# Heckington Fen Solar Park

EN010123

## Applicant Responses to Relevant Representations

Document Reference: ExA.RR response-D1.V1

Title: FIGURE 4.20: PROPOSED SITE ELEVATIONS OF SUBSTATION

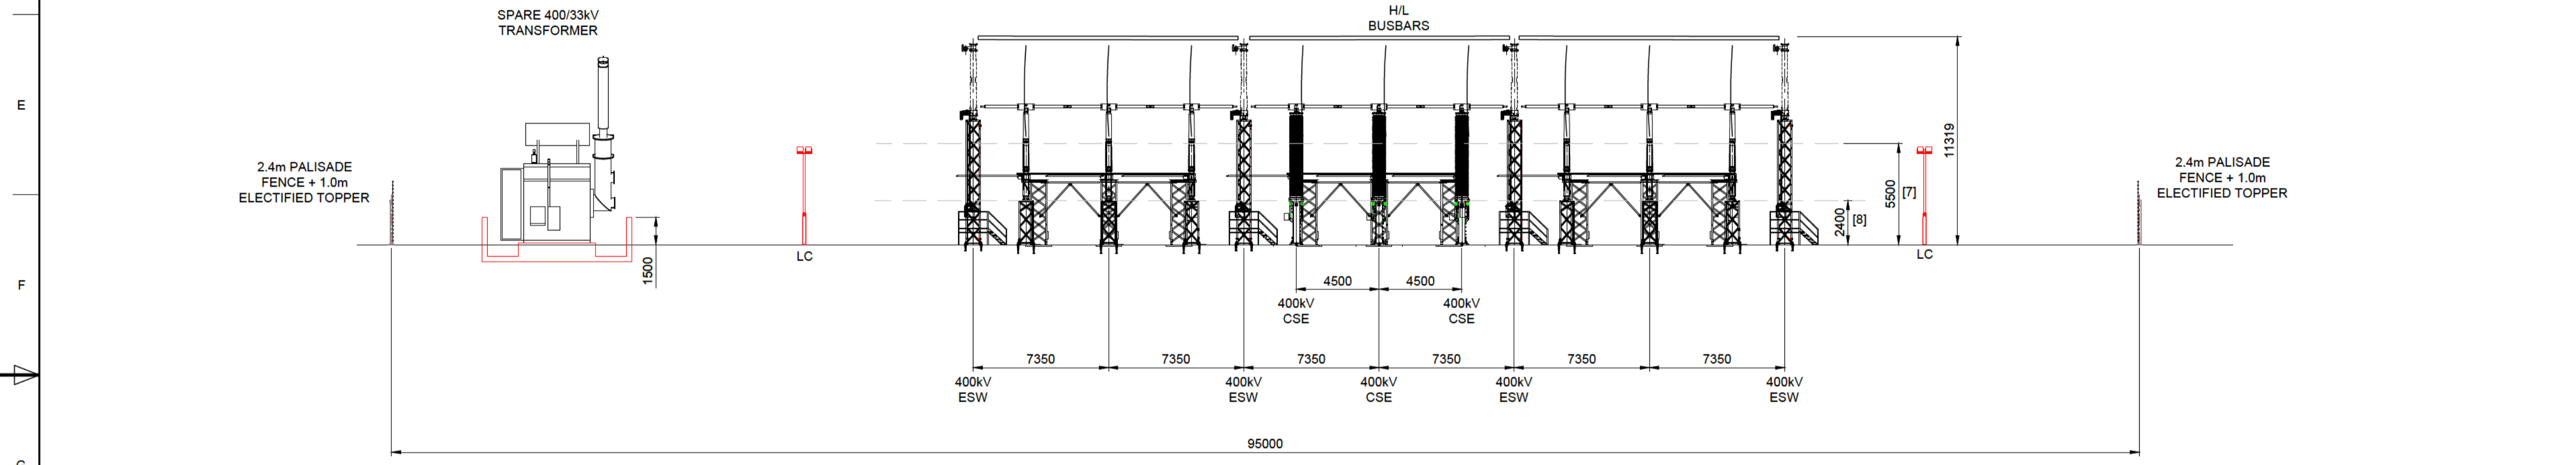
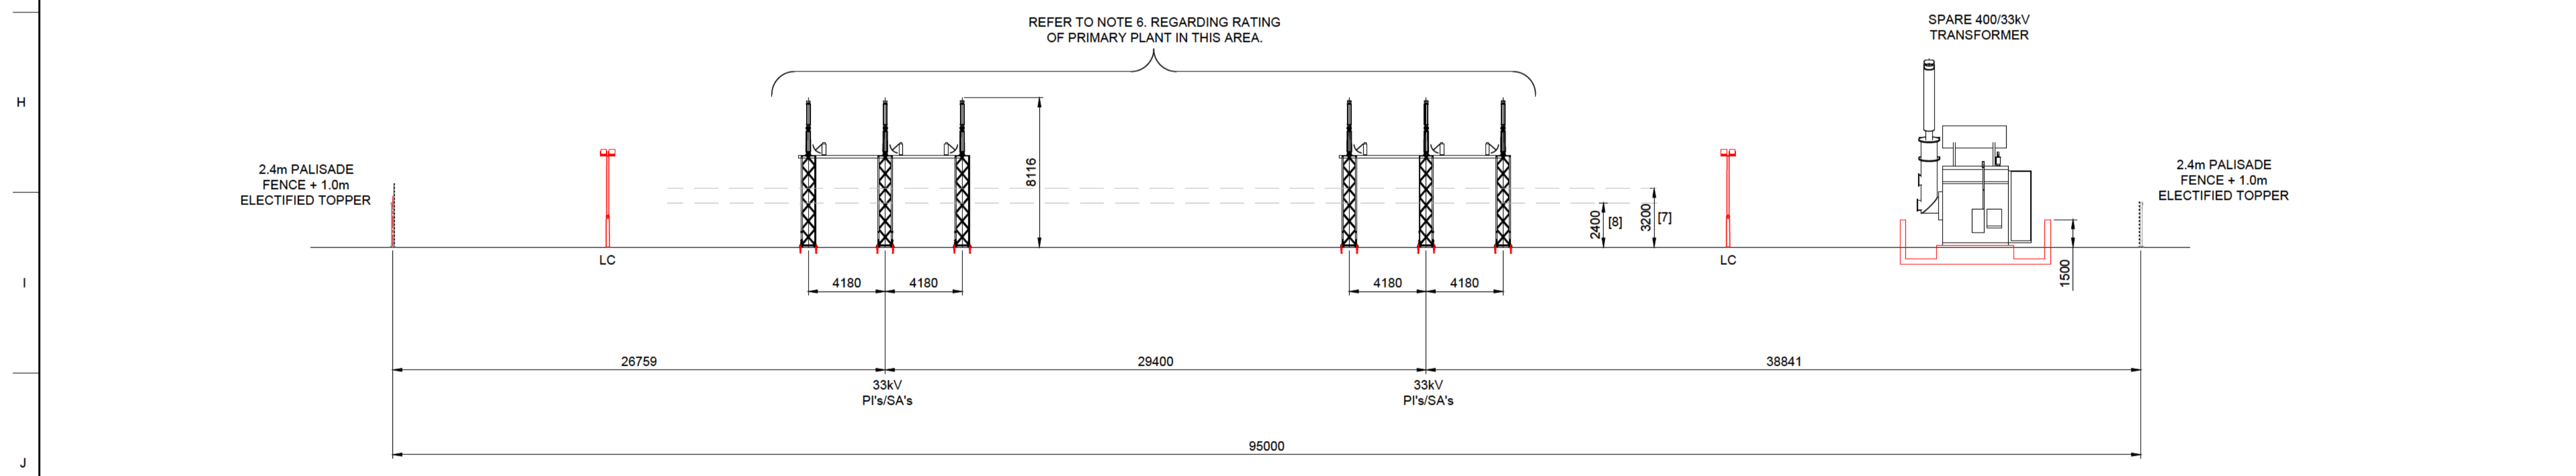
Flood Risk	Flood risk – The assessment of risk from a fluvial perspective is appropriate to the scale, nature and location of the development but clarification is requested in respect of the setting of finished floor levels for the control rooms.	The Applicant notes this comment and further details will be provided within the Outline Design Principles (APP-232) to capture this amendment at the next appropriate deadline.
Hydrology	Groundwater protection – based on the information available the Agency is	The Applicant notes this confirmation.
